## Department of Primary Industries

### **Wallarrah 2 Coal Project (SSD 4974) Comment on the Environmental Impact Statement**

### Wallarah 2 Coal Project (SSD 4974) Comment on the Environmental Impact Statement Detailed comments – DPI Water

**Figure 1.1 Tooheys Road Site, Conveyor, Rail Spur and Train Load Out Facility General Arrangement**

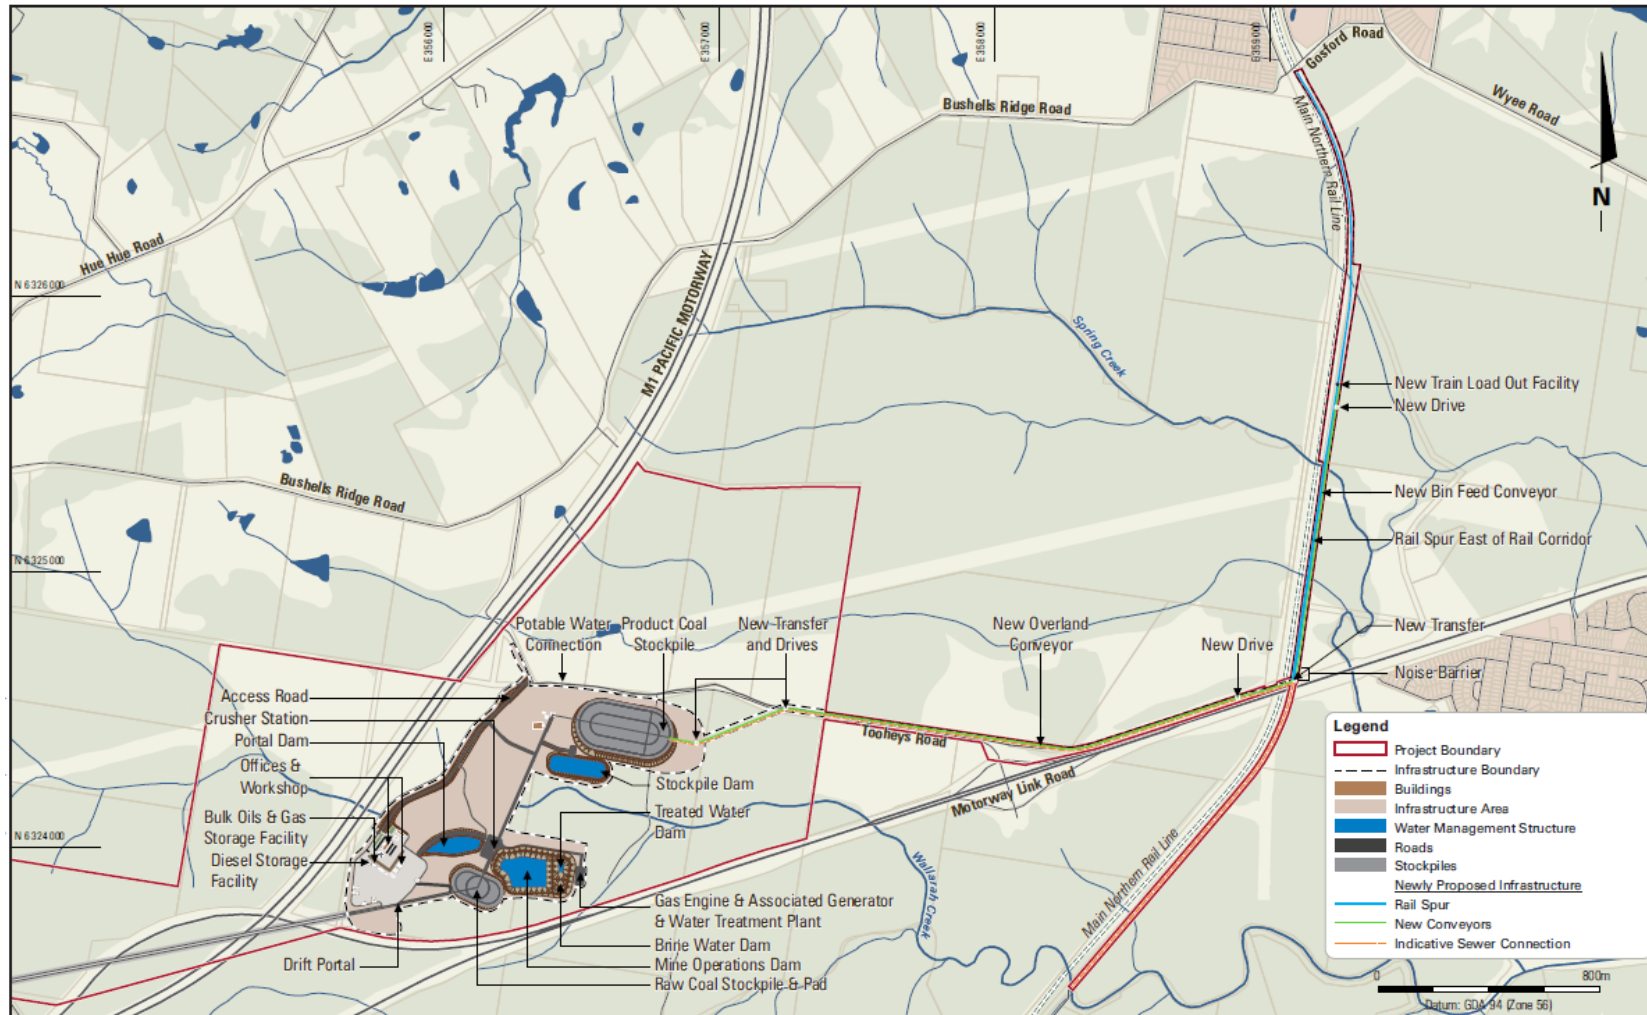
The re-design of the rail infrastructure has resulted in fewer interactions with watercourses and riparian vegetation to that previously proposed. The rail spur for the amended project requires three crossings of Spring Creek (and its tributaries), which are located directly adjacent to the existing crossings for the Main Northern Rail Line.

It is recommended that all works on waterfront land are consistent with DPI Water *Guidelines for Controlled Activities on Waterfront Land*.
